Your Ref: OWPC19038
Our Ref: FG/100/18/HH 15-05-2018
Please ask for:
Pat Aird

Retention of 1.8m high trellis fence to front boundary.

2 Sea Lane Gardens Ferring

Elevation to Sea Lane

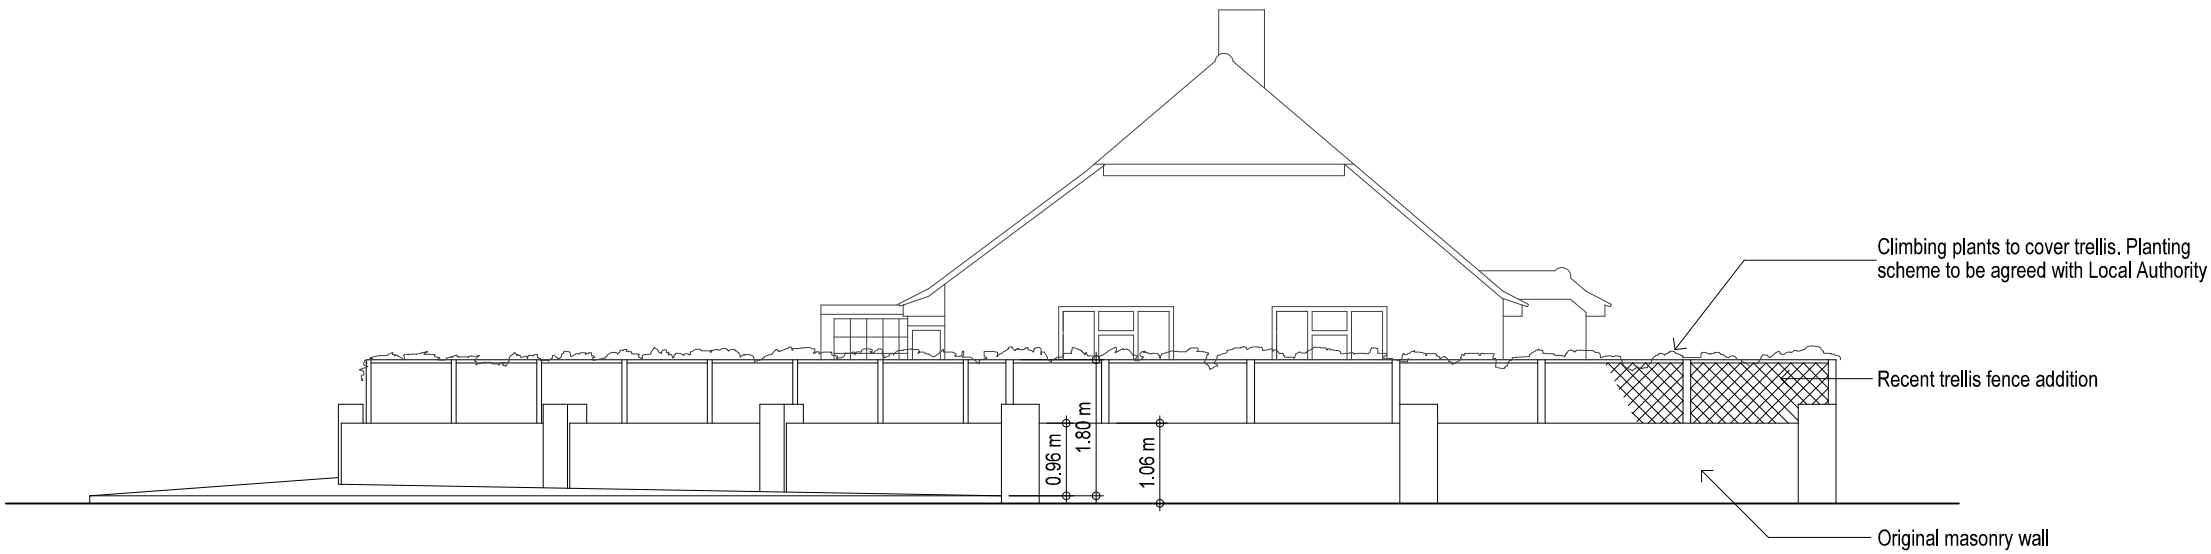
I visit my daughter regularly in Sea Lane Gardens and am no longer confident in exiting Sea Lane Gardens onto Sea Lane because of the height of the fence. No only is it dangerous it is also totally out of place with the row of cottages in Sea Lane. I also understand that fences should not be higher than 1 metre high adjoining the highway
